**133 Forward Avenue**

**Urban Design Brief**

## Urban Design Brief

The following Urban Design Brief has been prepared in accordance with the Terms of Reference provided to the Applicant by the City following the July 28<sup>th</sup>, 2025, Pre-Consultation Meeting. The Terms of Reference were provided via email on August 8<sup>th</sup>, 2025.

**SITE PLAN**

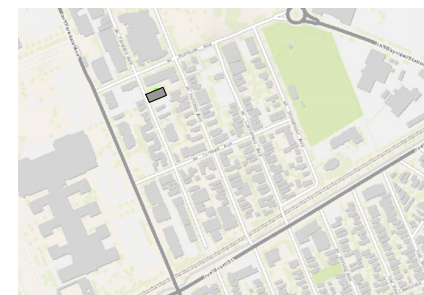
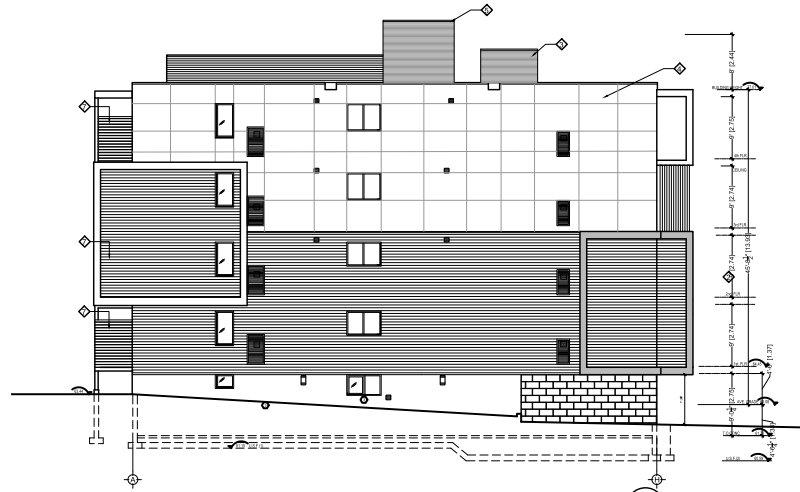
15. The following elements of the preliminary design are of concern:
  - Is there suitable rear yard setback?
    - A 7.5m rear yard is shown on the site plan thereby meeting the requirements of the zoning by-law. Further, the applicant has been in communication with the City's Real Estate group (CREO) to purchase the closed lane at the rear of the property to add additional rear yard space.

- What is the future of the north property line? There is a one storey structure on the property line, will there be enough residual space to allow passage? Or is it possible to build this development on that property line affording more space to the south for accessibility and garbage removal?

- We are not aware of future plans for the property to the North. A 1.5m setback has been provided from the northern property line as required by the by-law.
